**WELWYN HATFIELD BOROUGH COUNCIL
EXECUTIVE DIRECTOR - PLANNING, PUBLIC PROTECTION AND GOVERNANCE**

DELEGATED APPLICATION

Application No: 6/2019/1113/EM
Location: 23 Lemsford Lane Welwyn Garden City AL8 6YN
Proposal: Erection of a single-storey rear extension
Officer: Mrs Kerrie Charles

13643-P001-B

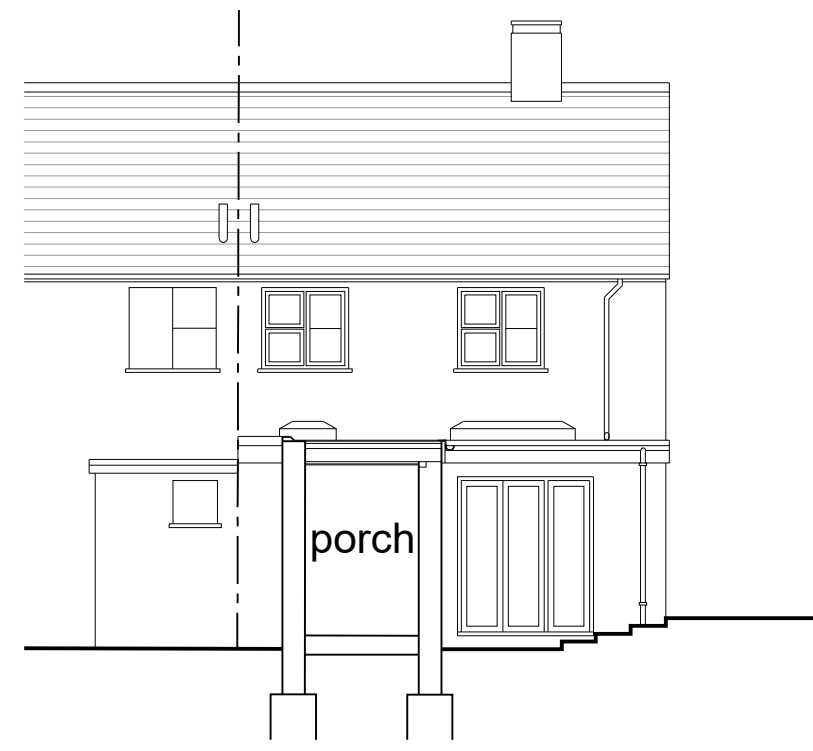
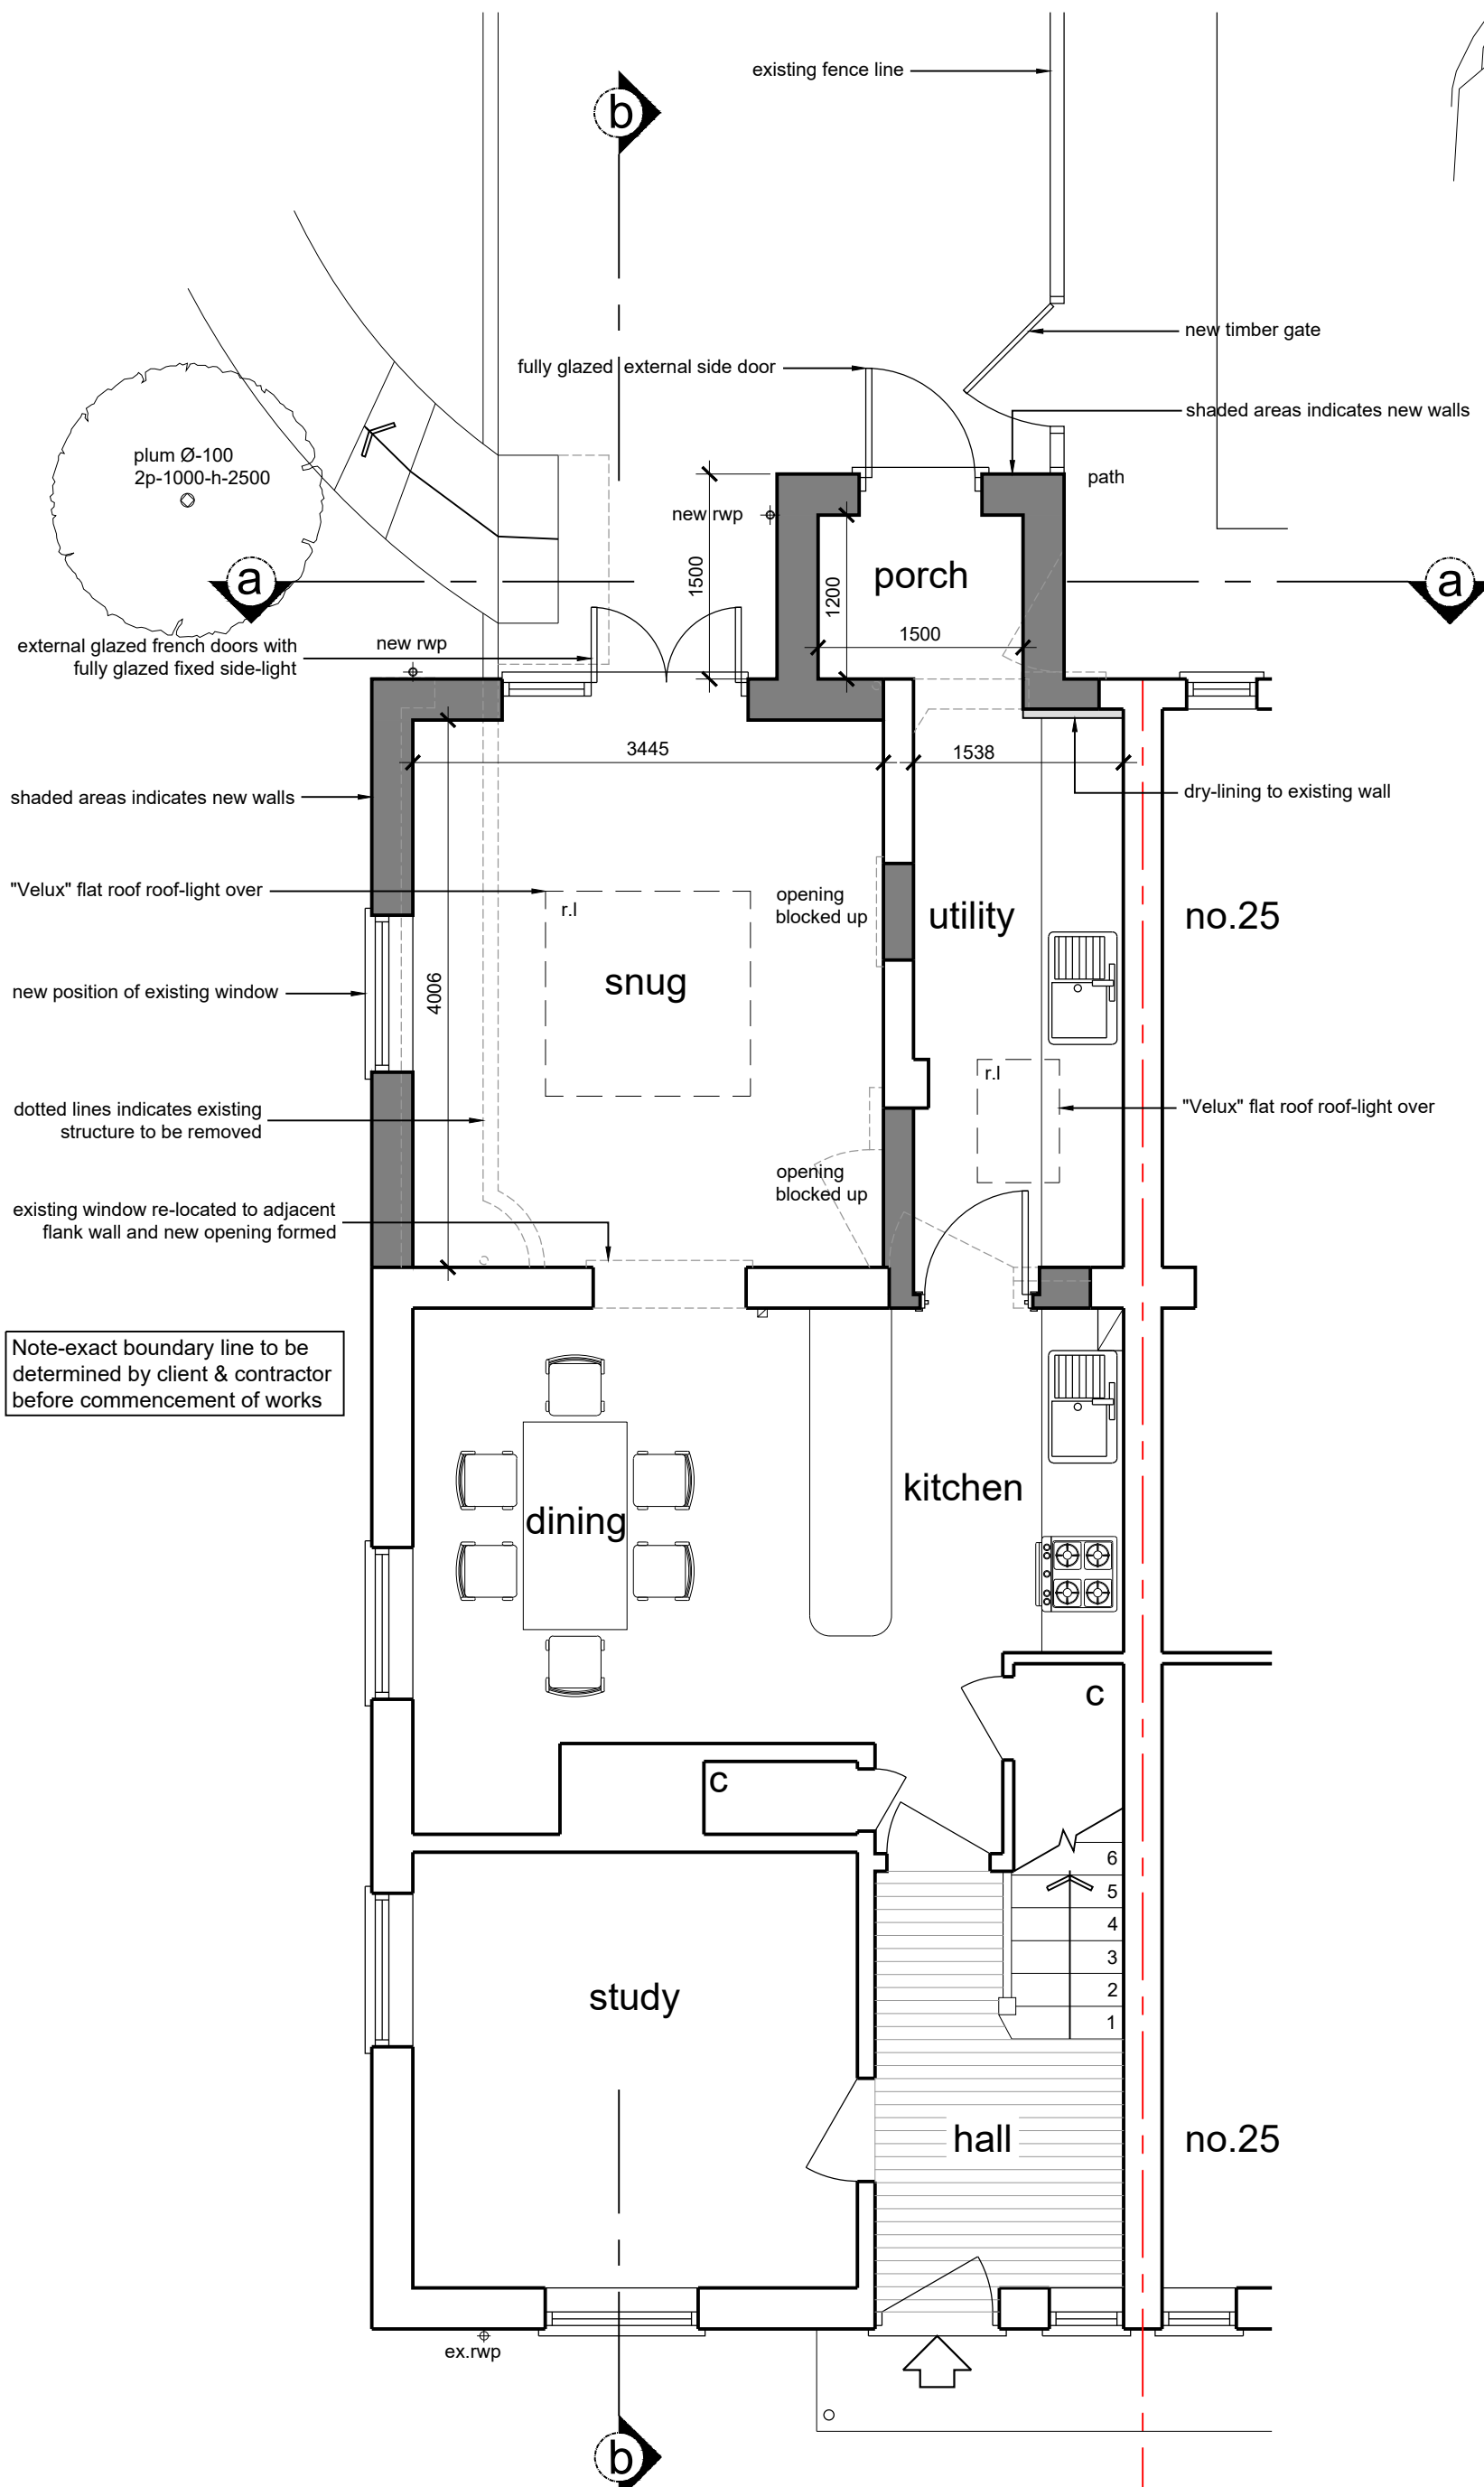
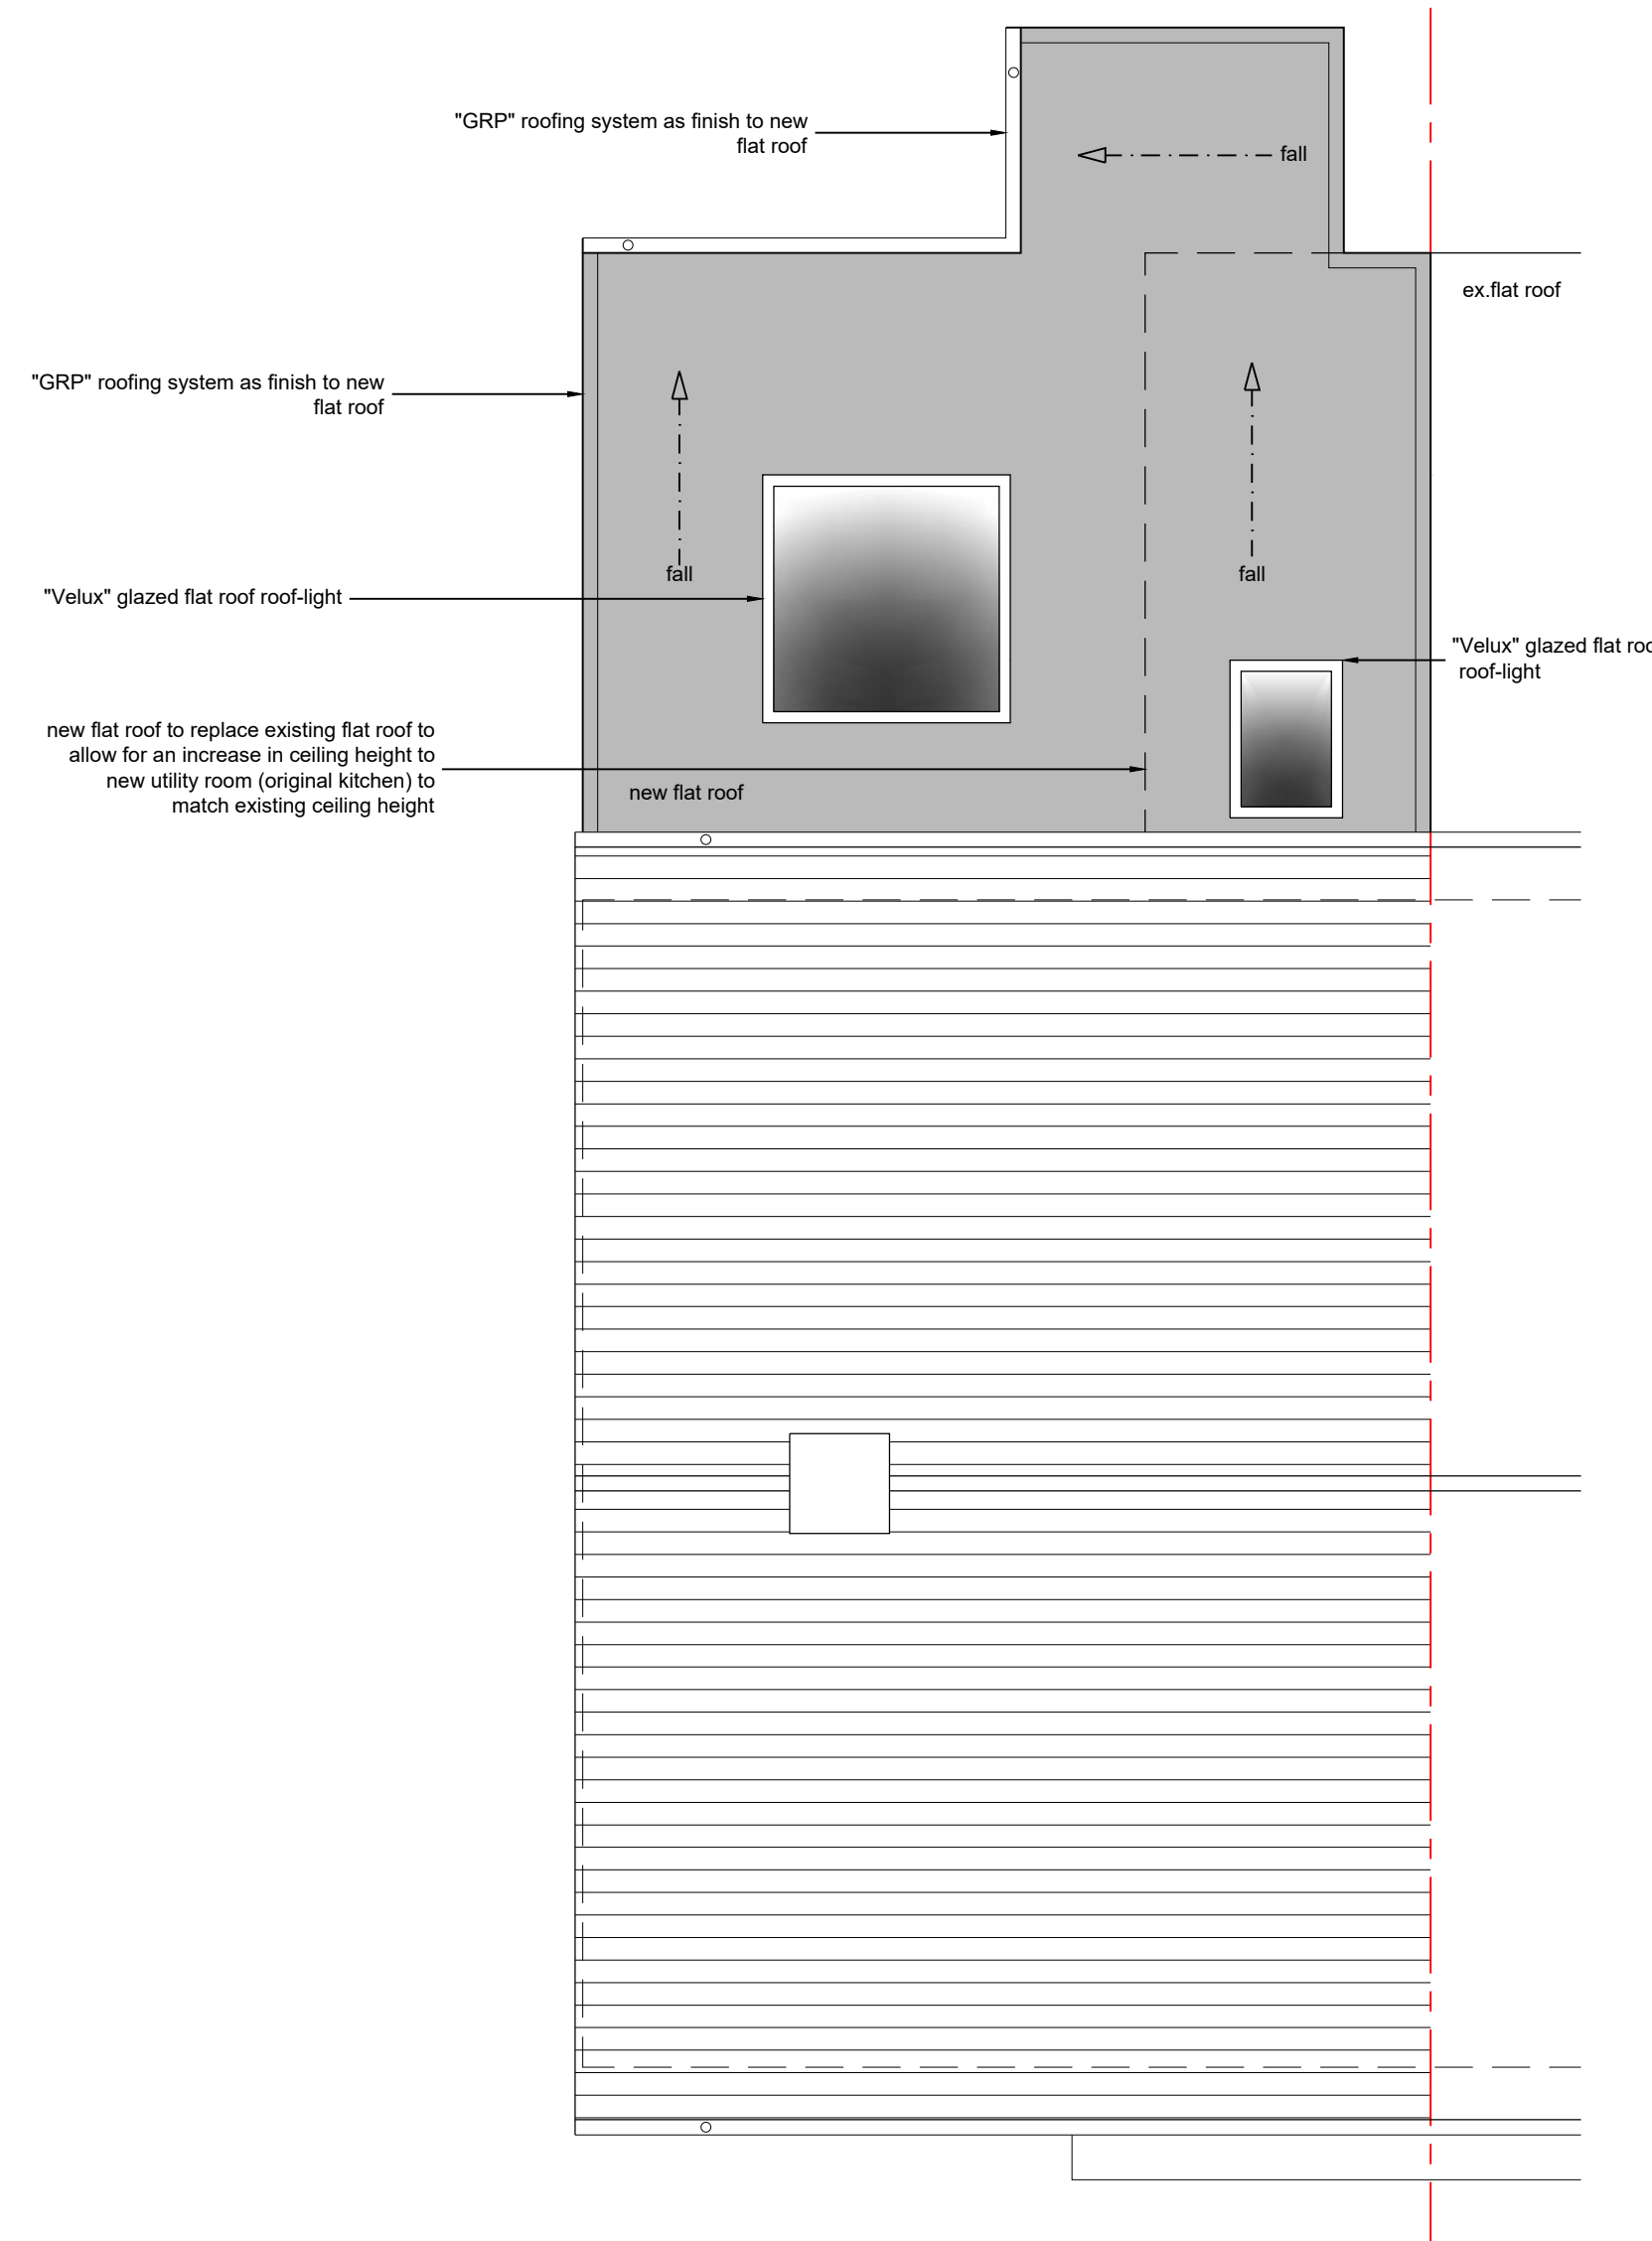
Comment (if required): The proposed extension would be located to the rear of the host dwelling, and although the extension would be slightly visible within the streetscene due to being located on a corner plot the size and design would not be overly prominent being a single storey extension and well screened by existing boundary treatments. As such it would not be a detrimental feature within the streetscene.

The proposed extension being single storey would not appear at odds, and would be subordinate to the host dwelling. The proposed materials are to match the existing dwelling so on balance, it is considered that the design would relate well to the host dwelling.

Comment (if required): The extension will project a further 1.5m metres from the neighbouring properties boundary wall. The extension being single storey is not considered to impact on the adjoining neighbouring properties amenity in terms of loss of light, privacy or outlook.
